From: [Jeremy Johnston](#)
To: "Spencer Parr"; "Josh Mitchell"
Cc: [Kelly Bacon \(CD\)](#); [Jeremy Larson](#)
Subject: RE: Swiftwater Storage CUP and Residential Building Application Parcel 15445
Date: Wednesday, June 16, 2021 8:04:27 AM
Attachments: [20182-Final.pdf](#)

The site plan you provided does indicate appropriate setbacks for the residence. It has been a mad house around here so I apologize for the delay in relaying this information. I just spoke with Jeremy Larson and have CC'd him on this response as well. The site plan provided (and attached here) demonstrates compliance with all shoreline and critical area setbacks. CDS Planning has no issues with this residential proposal as presented.

Kittitas County CDS, Planning Official

WLC PROPERTY HOLDINGS LLC
SITE PLAN

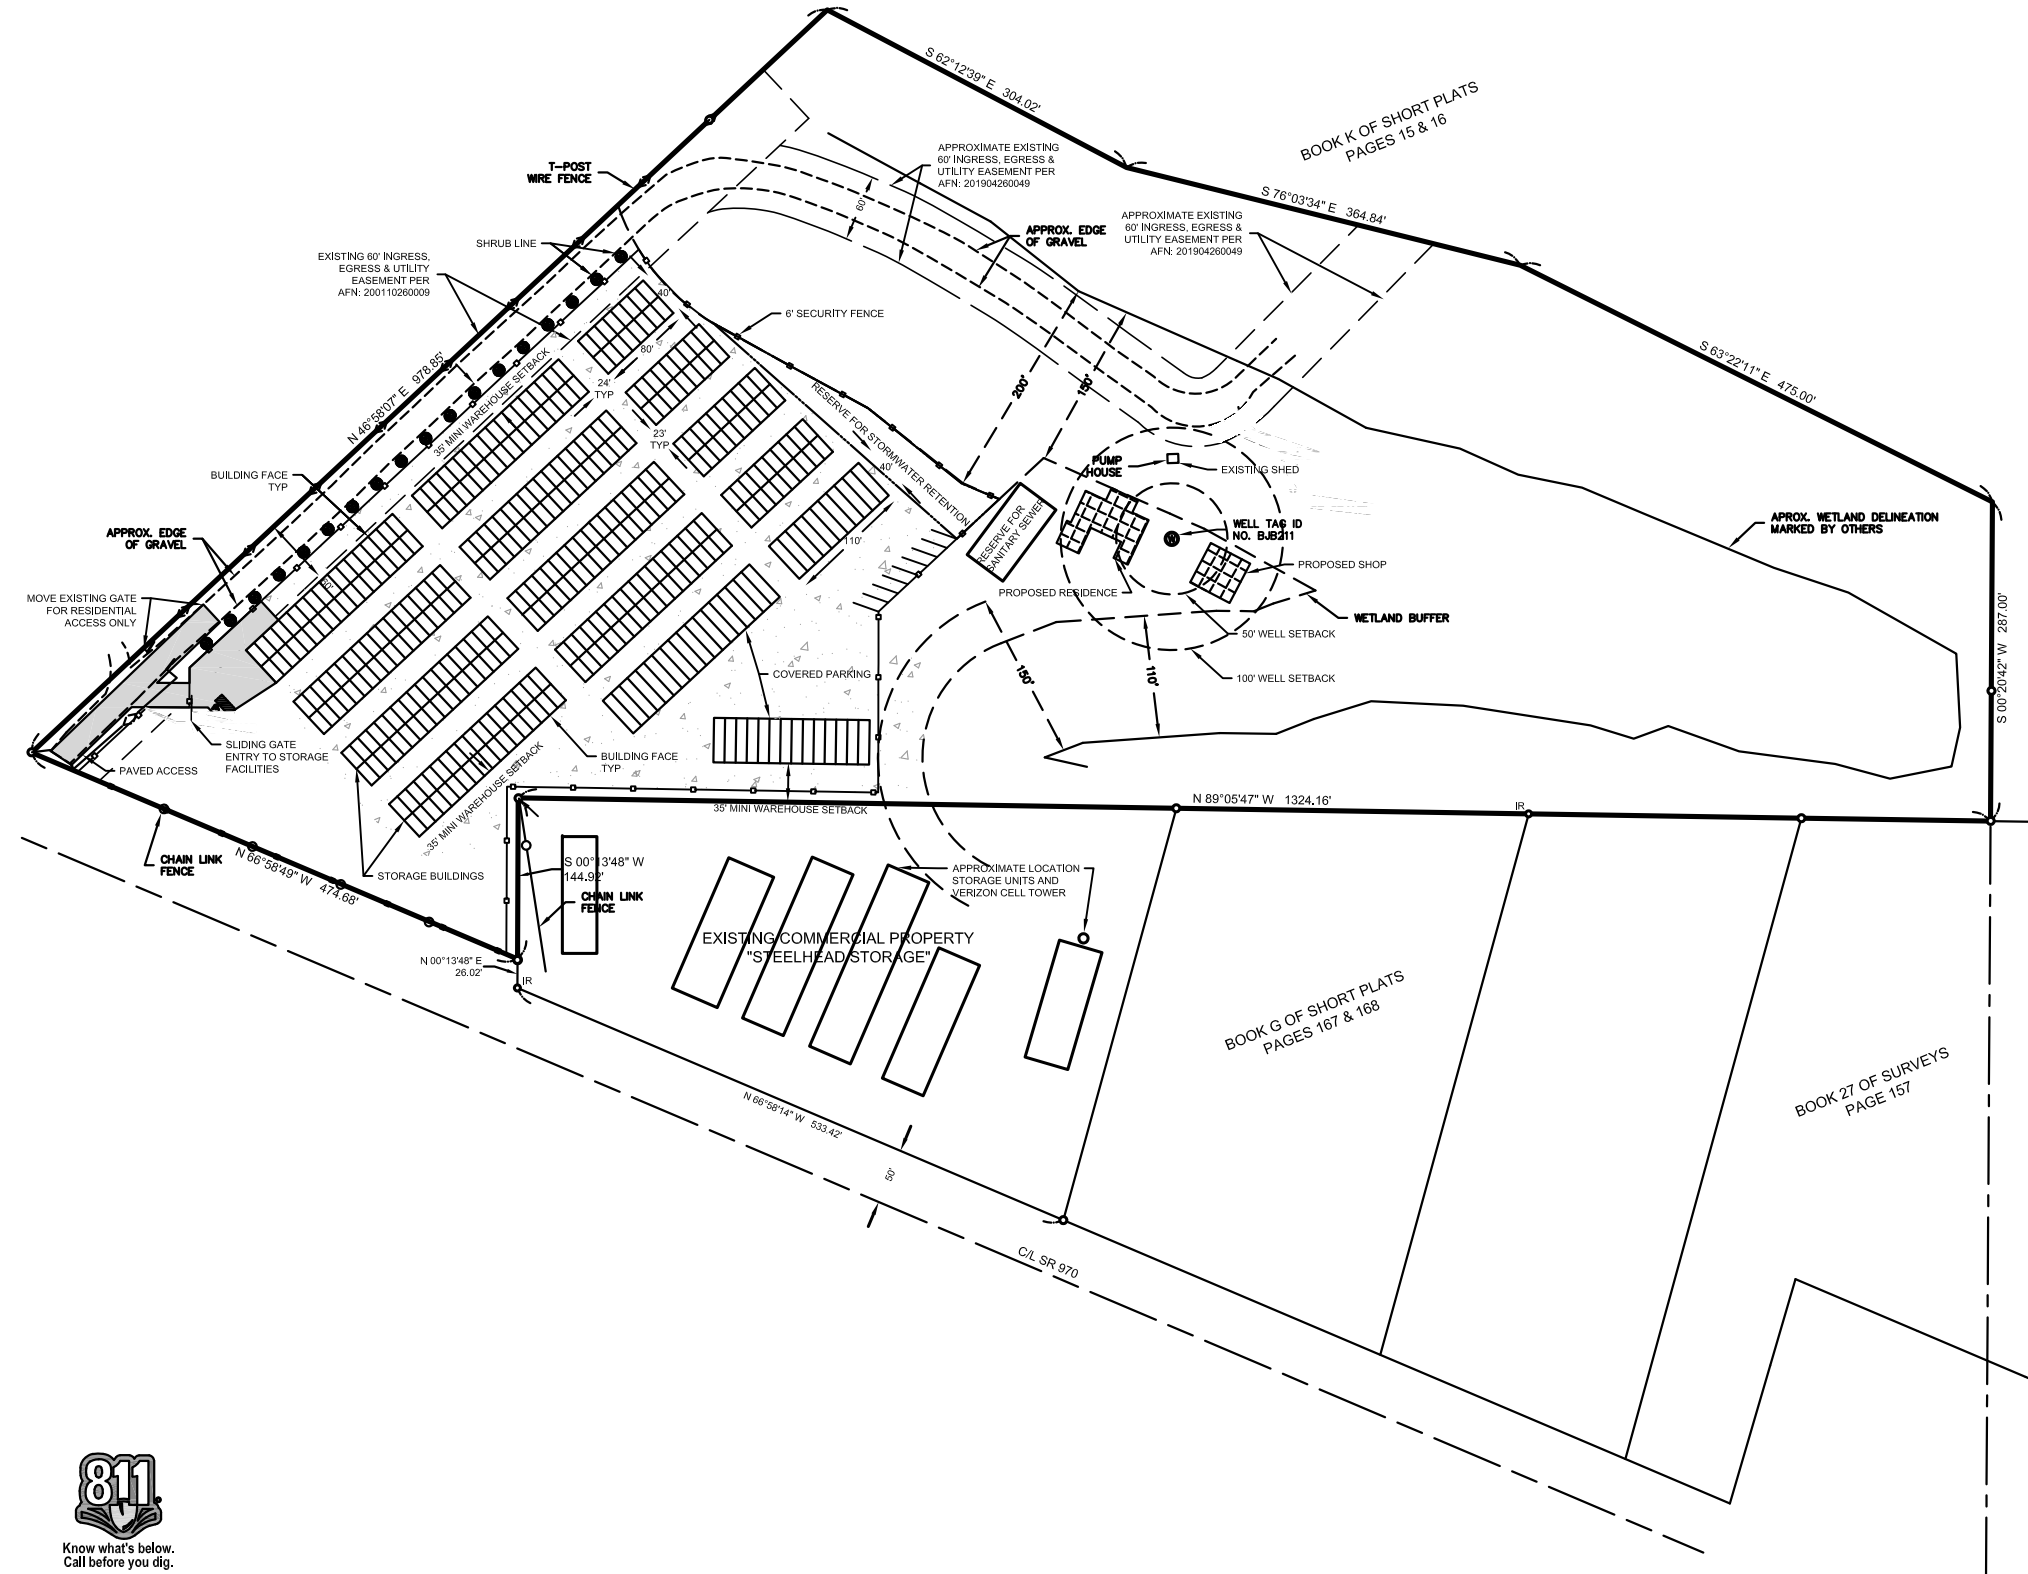
Please note that all proposed commercial construction, including even the storm water retention placement will be at least 200+ feet from the Category II wetlands along our northern boundary and at least 150+ feet from the Category III wetlands at the southern boundary.

Similarly, all proposed residential construction is at least 150+ feet from the northern wetlands and 110+ feet from the southern wetlands. Our residential septic fields are located more than 100 feet from the well.
